Case Officer: Shona King

Recommendation: Approve

Applicant: Jacobs Douwe Egberts

Proposal: Demolition of existing office block and erection of surface level car park providing 215 replacement car parking spaces, including landscaping and other associated works; new main entrance and reception of the Computer Suite, with external re-cladding

JOB NO. 16061	DRAWING (03)-S-001	REV PL1
------------------	-----------------------	------------

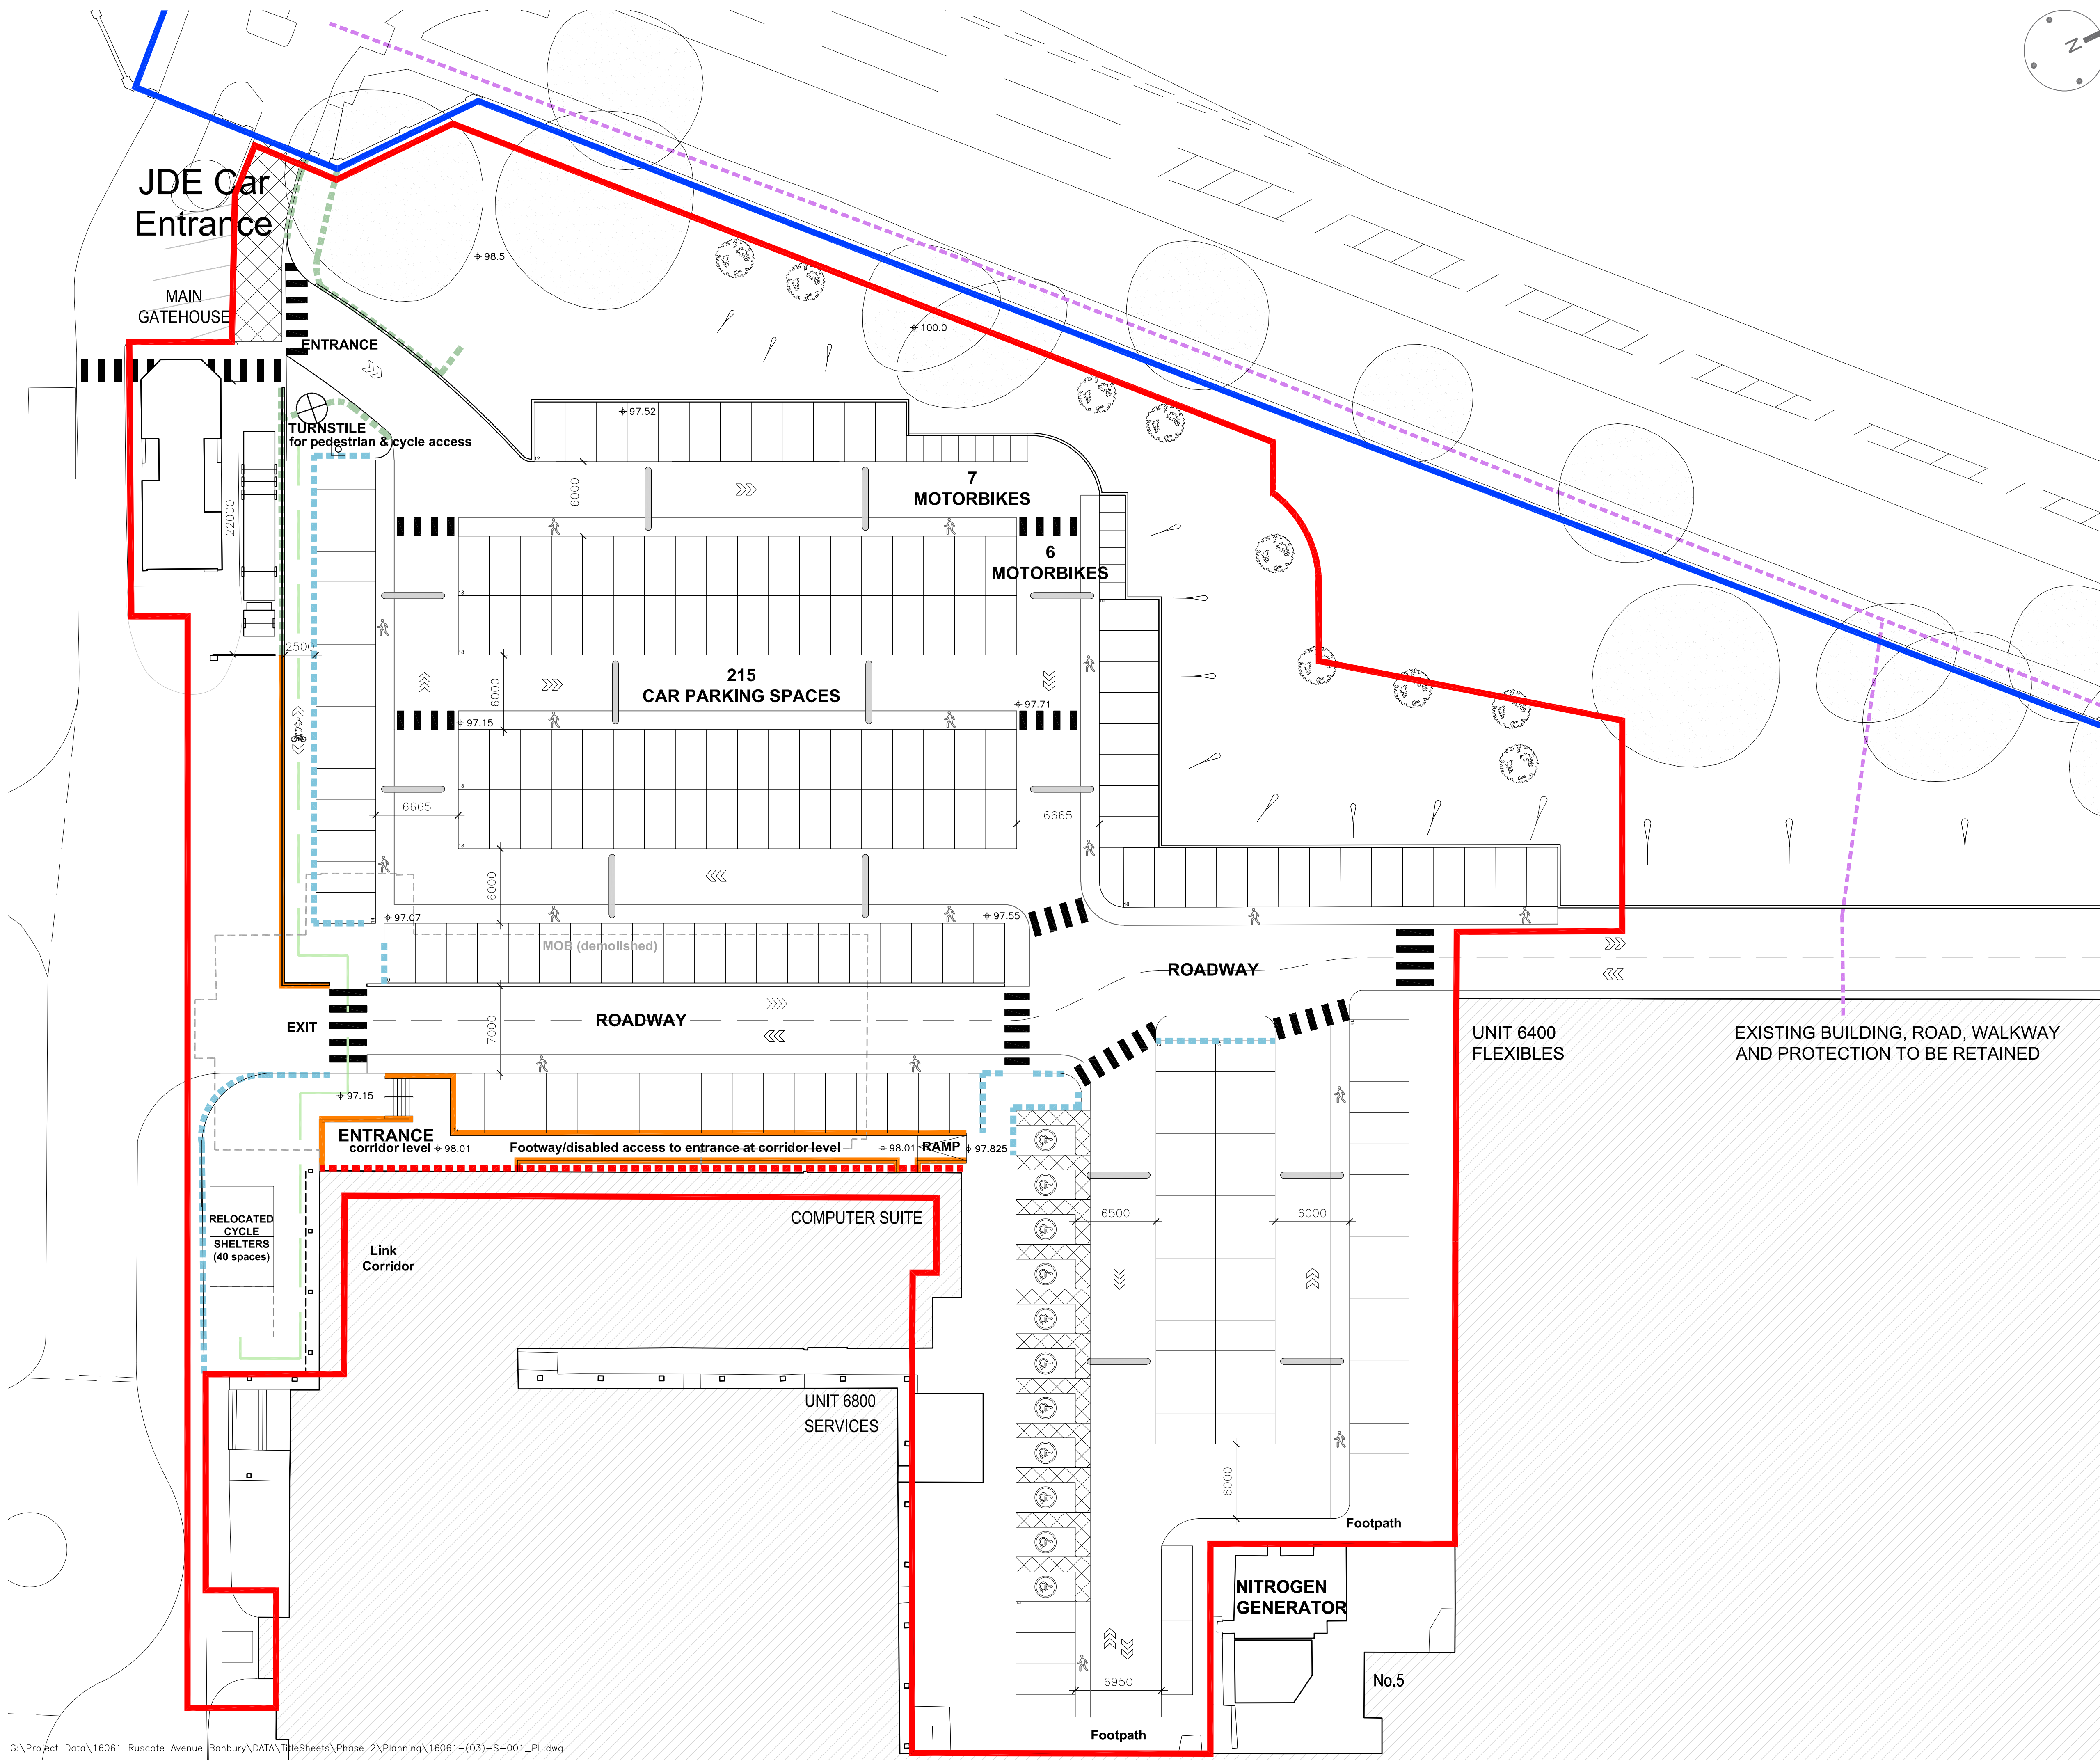
- 8.12. However, the LHA has raised concerns that the parking spaces are undersized, and originally recommended a revised parking layout be required by condition. Following comments from the agent regarding the size of the car parking spaces and the requirement only for residential spaces to measure 2.5m x 5m the LHA has recommended that the condition to increase the size of the spaces is not required but a condition is necessary to ensure that the car park is drained within the site curtilage and the area is retained for parking at all times. Also, the car park plan needs to illustrate EV charging infrastructure which may affect the layout.

3. Prior to the construction of the car park hereby approved, and notwithstanding the details submitted, a plan showing a car parking provision for 215 spaces to be accommodated within the site to include layout, surface details, and drainage, shall be submitted to and approved in writing by the Local Planning Authority. Thereafter, and prior to the first occupation of the development, the parking spaces shall be laid out, surfaced, drained and completed in accordance
